Letter of Notice to Adjacent Property Owners

This letter is being sent to you because Richmond American Homes is proposing a land use project in El Paso County at the referenced location: lot 23 of Springs at Waterview Filing No. 1, otherwise known as 4878 Wolf Moon Drive. Please direct any questions on the proposal to the referenced contacts below. Prior to any public hearing on this proposal a notification of the time and place of the public hearing will be sent to the adjacent property owners by the El Paso County Planning Department. At that you will be given the El Paso County contact information, the file number and an opportunity to respond either for, against or expressing no opinion in writing or in person at the public hearing for this proposal. Adjacent properties requiring notification are lots 10, 11, 22, 24, 73, and 74 of Springs at Waterview Filing No. 1. At this time, lots are owned by builders and none of the lots are occupied.

PLOT PLAN LOT 23

SUBDIVISION: SPRINGS AT WATERVIEW FILING NO.1

PLOT PLAN LOT 23

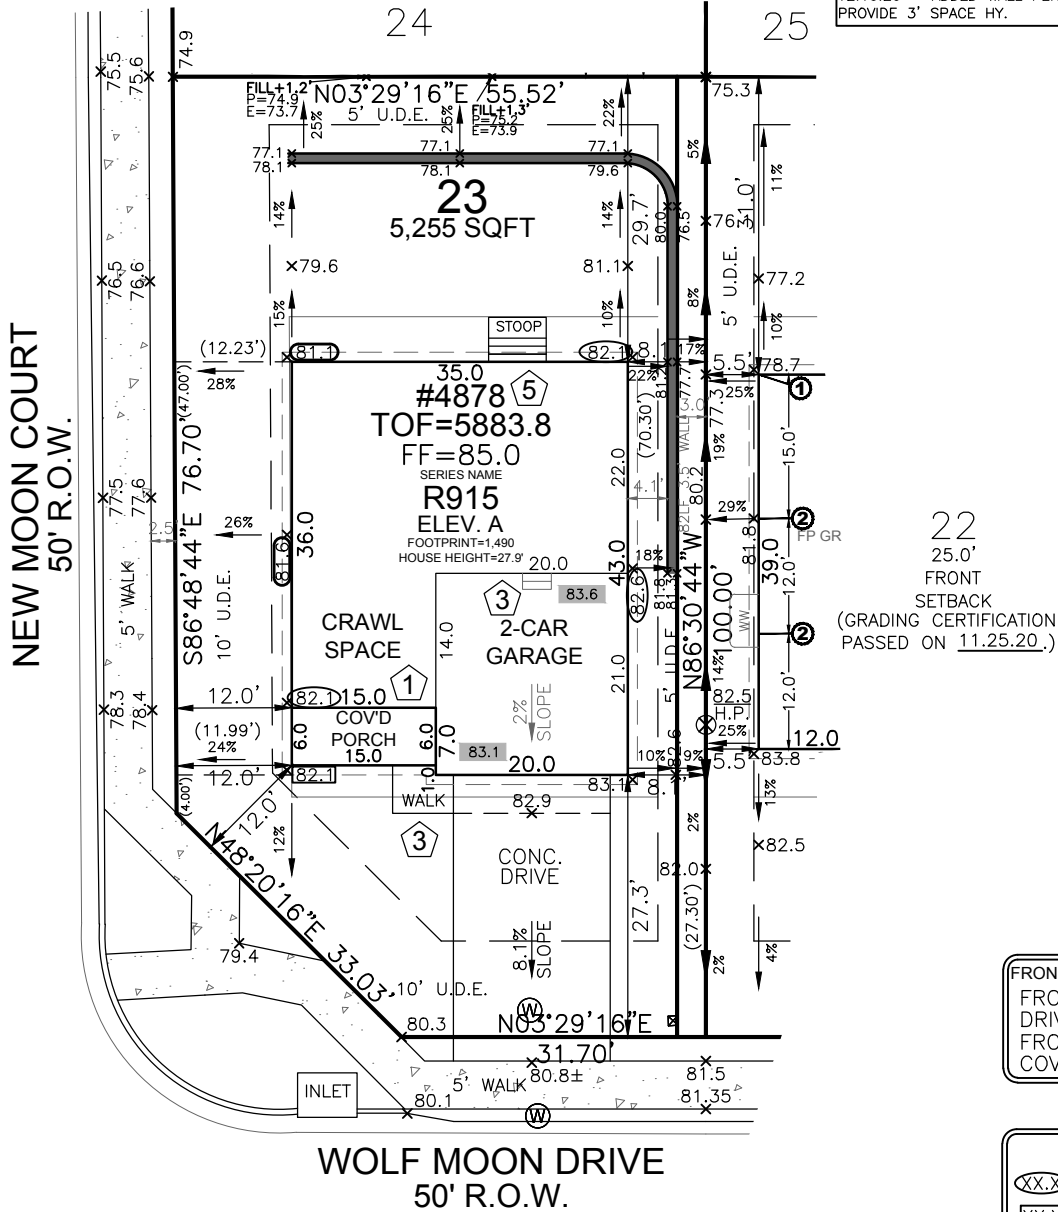
WATER METER IS IN DRIVEWAY; WILL NEED TO BE RELOCATED.

PLOT PLAN LOT 23

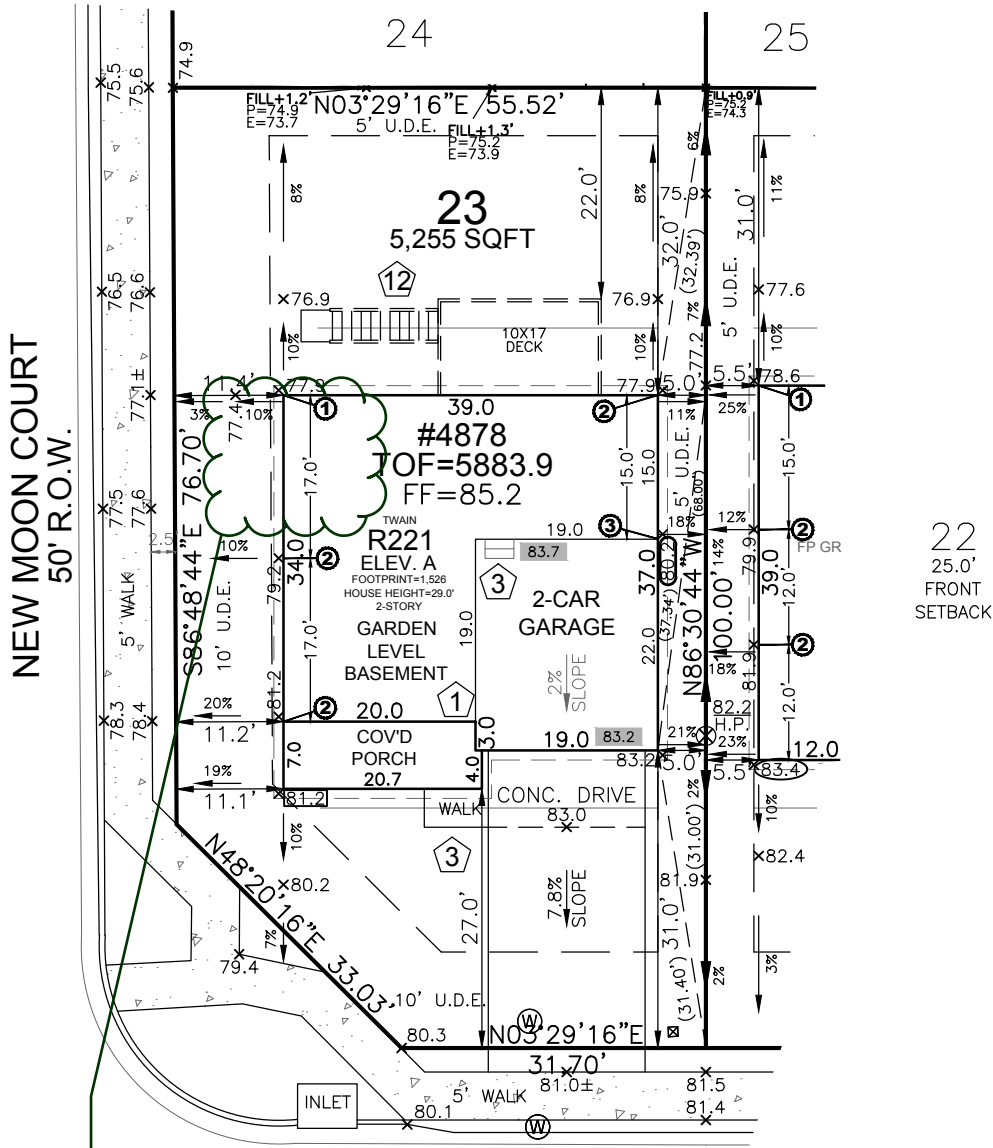
Proposed setback is not within 20% of required setback of 15 feet to qualify for Admin. Relief. The required setback on the second front yard on a corner lot is 1/2 of the required front yard or 15 feet, whichever is greater. 15 feet is greater than 12.5 feet, or half of the front yard required. Therefore, the reduction can only be requested up to 12 feet (80% of the 15 feet required)
